From: Joanne Lewis
Sent: 17 April 2019 11:03
To: Planning.Responses
Cc: Anna Appleton
Subject: F/7/19/PL Waterbury House, Ford

F/7/19/PL Waterbury House, Ford

Client Consensus Caring Homes Group		
Project Information Proposed 5 Apartments, Waterbury House, Ford Road Arundel		
Drawing Title Proposed Plans and Elevations		
A1 Scale 1:100	A3 Scale 1:200	
Job Number H.17.37	Drawing Number (00) 1	Revision H
Drawing Issue PLANNING

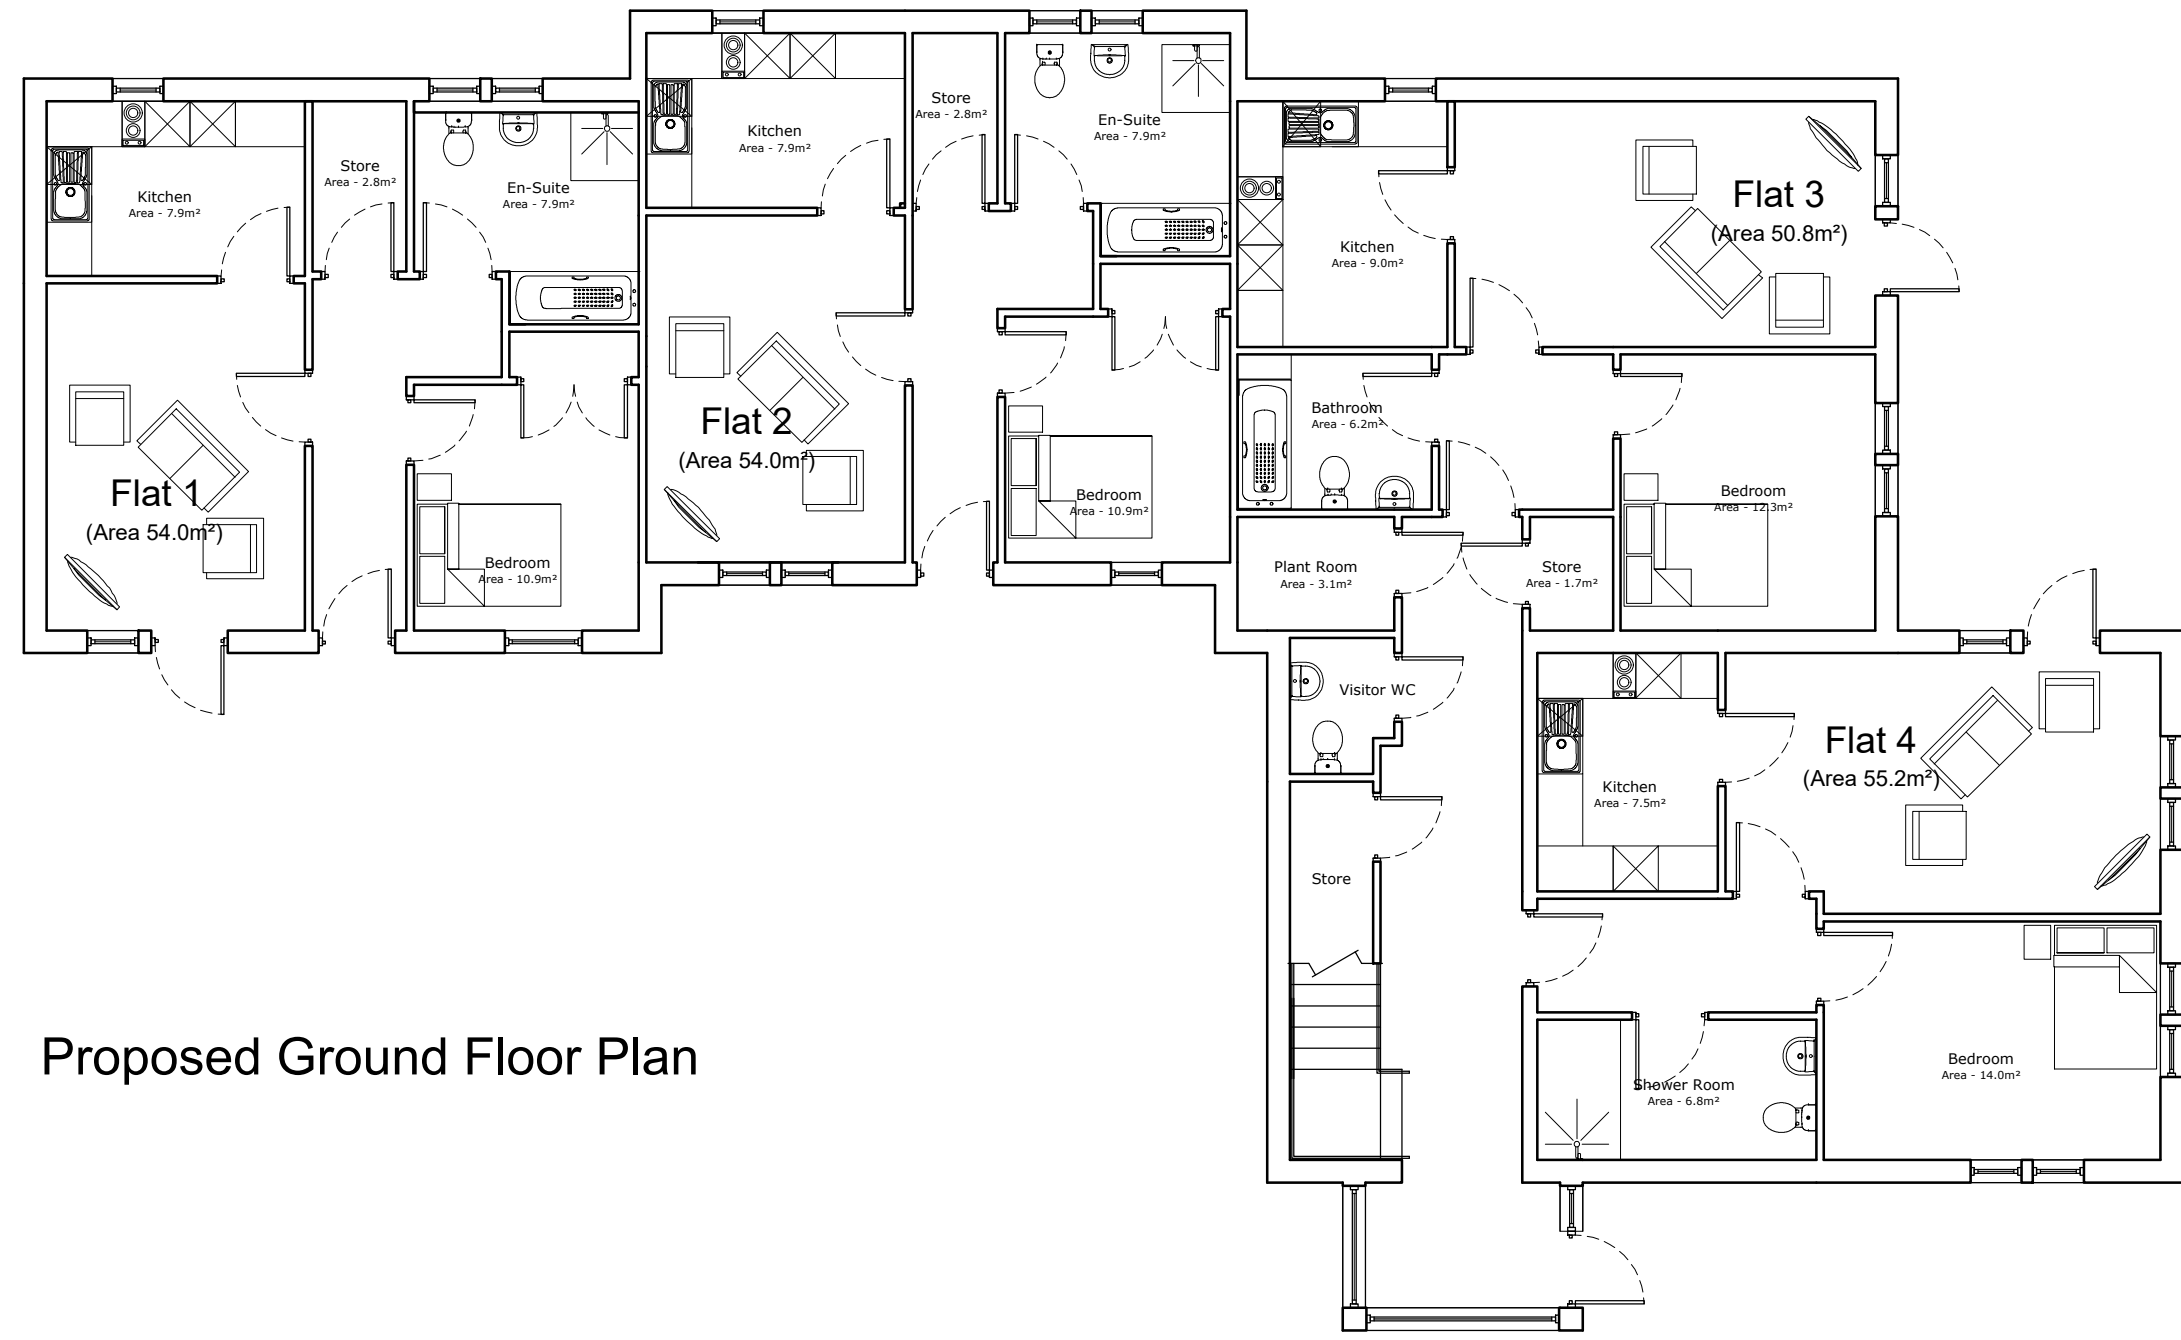
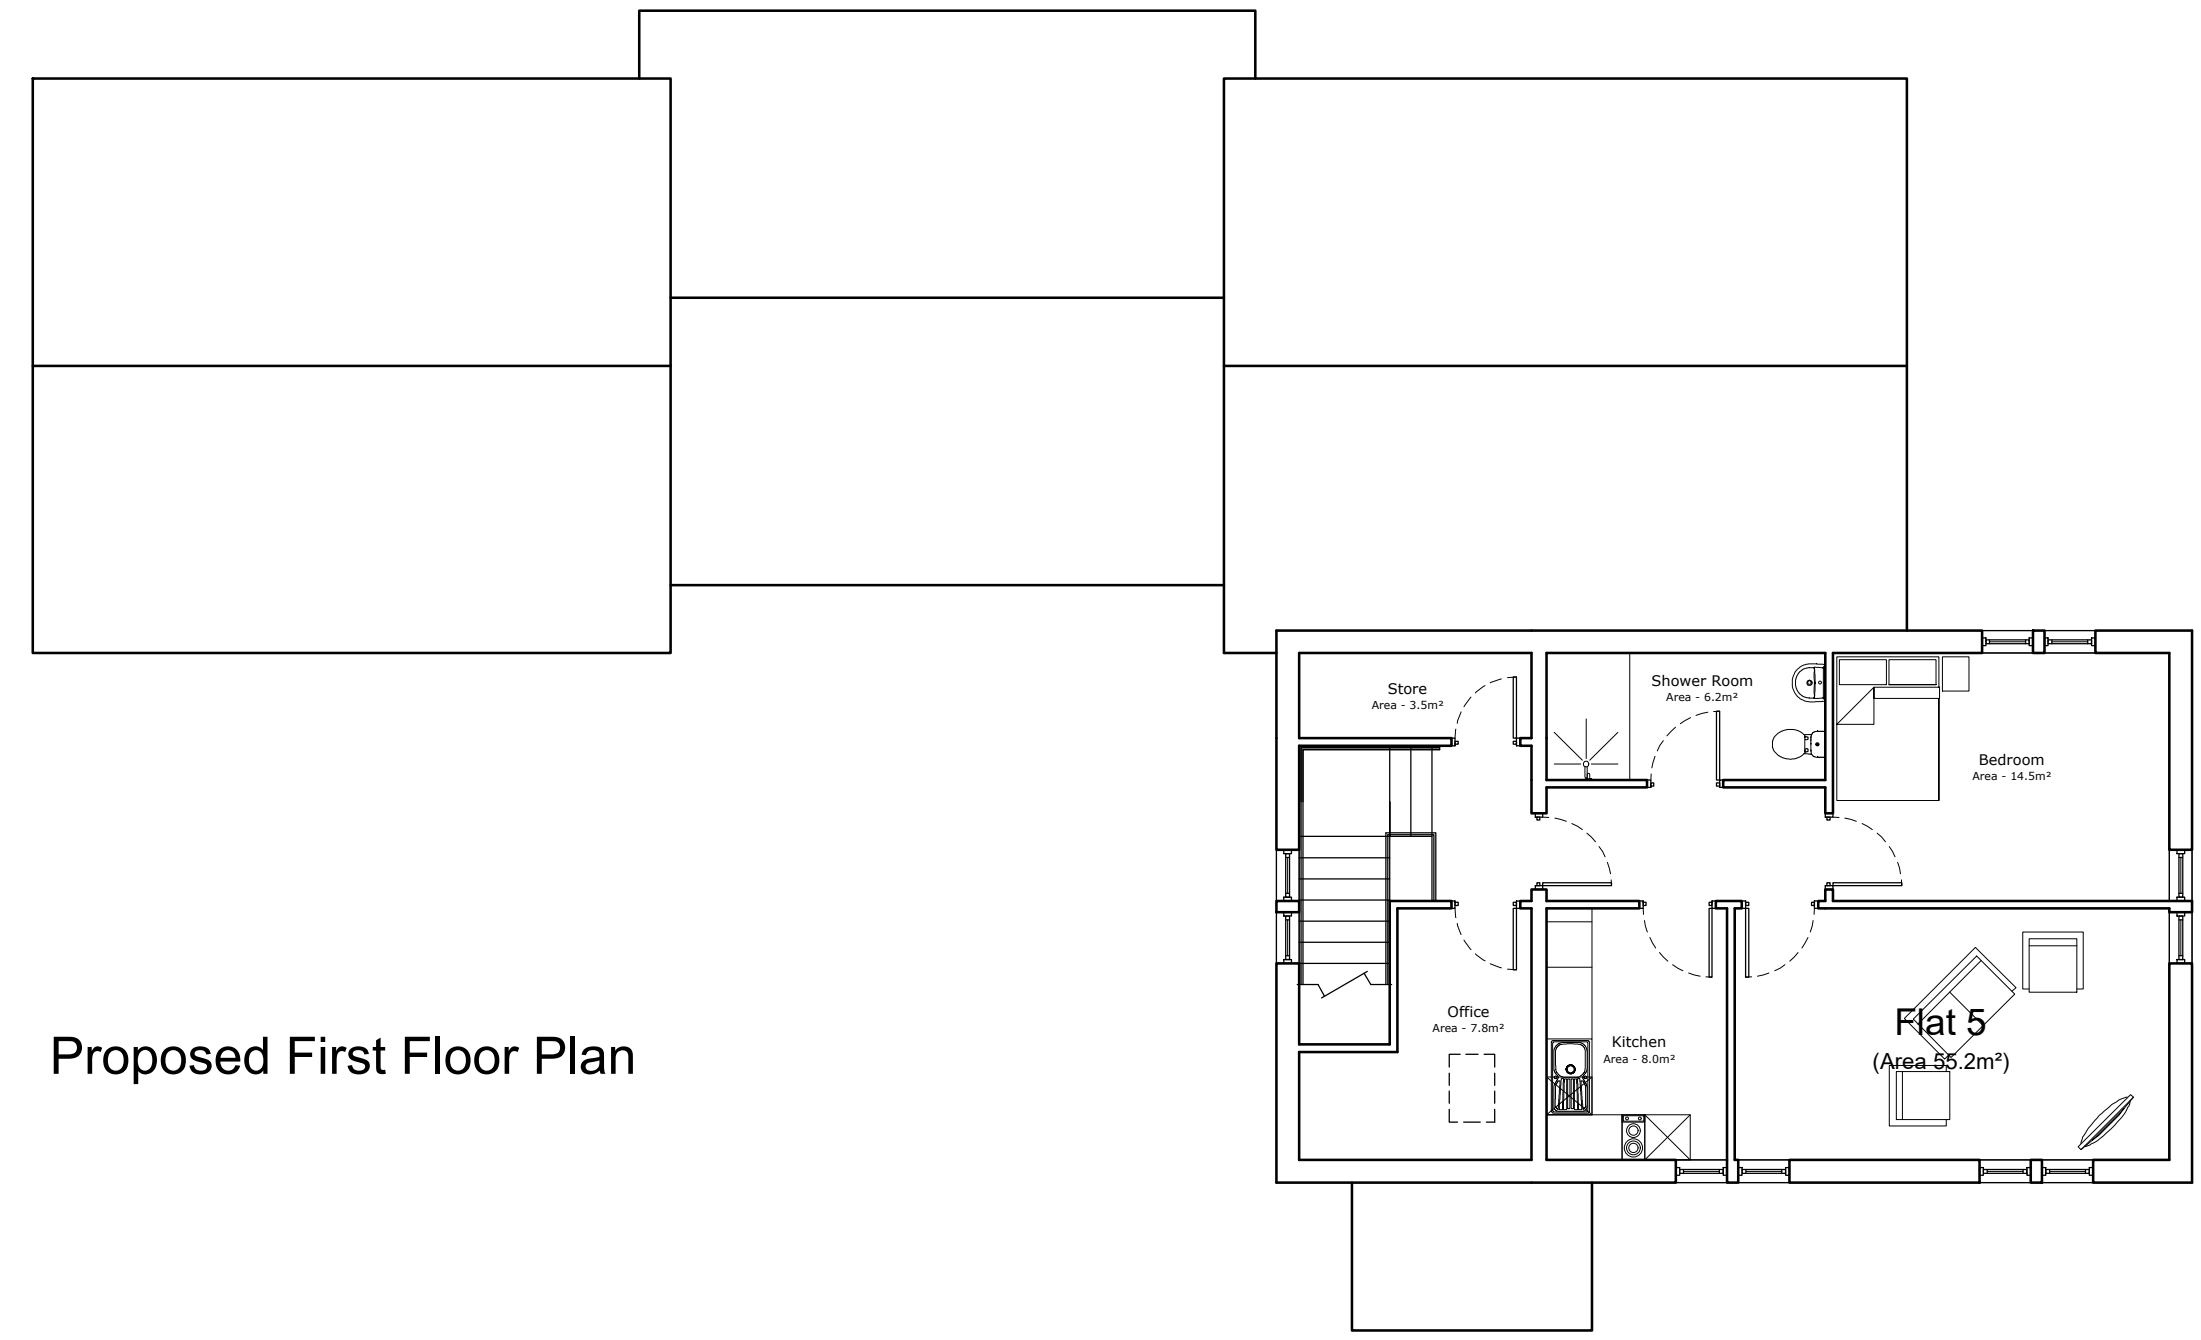
I can see that the layout of the flats has been altered to move bedrooms away from the railway but living rooms are still located close to the railway and I cannot see any information on plans to protect the outdoor amenity space from noise from the railway.

The acoustic report and any proposed mitigation scheme should demonstrate that the internal noise levels within the residential units will conform to the "Indoor ambient noise levels for dwellings" guideline values specified within Table 4 under section 7.7.2 of BS 8233:2014. The scheme should also take into account the correct number of air changes required for noise affected rooms.

The scheme should also demonstrate that the external noise levels within the curtilage of residential units will conform to the "Design criteria for external noise" upper guideline value of 55 dB L_{Aeq,T} as specified within section 7.7.3.2 of BS 8233:2014 Guidance on sound insulation and noise reduction for proposed developments.
